CITY OF ALBUQUERQUE

November 21, 2025

RE: 6105 La Cholla Ct NE
Grading & Drainage Plan
Engineer's Stamp Date: 11/17/25
Hydrology File: E23D003O3
Case # HYDR-2025-00410

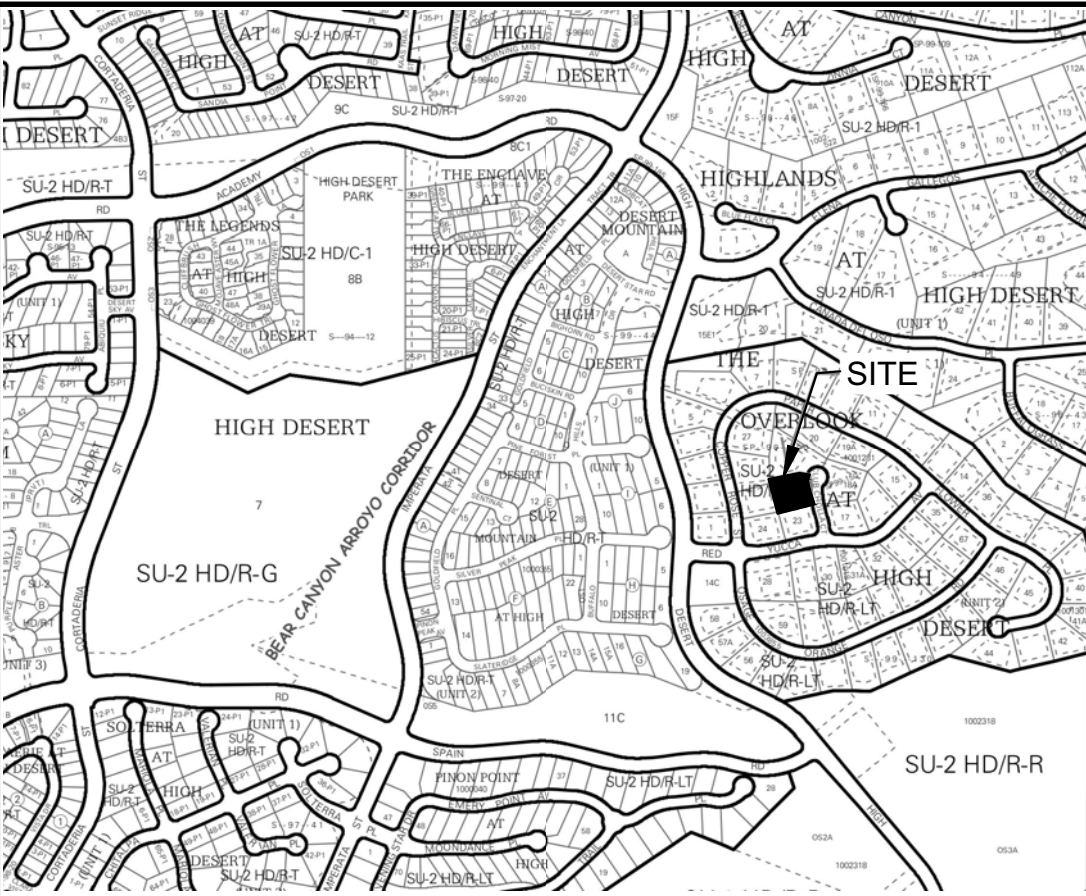
1. Please show the sidewalk on the plan or submit for a Sidewalk Waiver if the intent is to defer the improvement to the future.
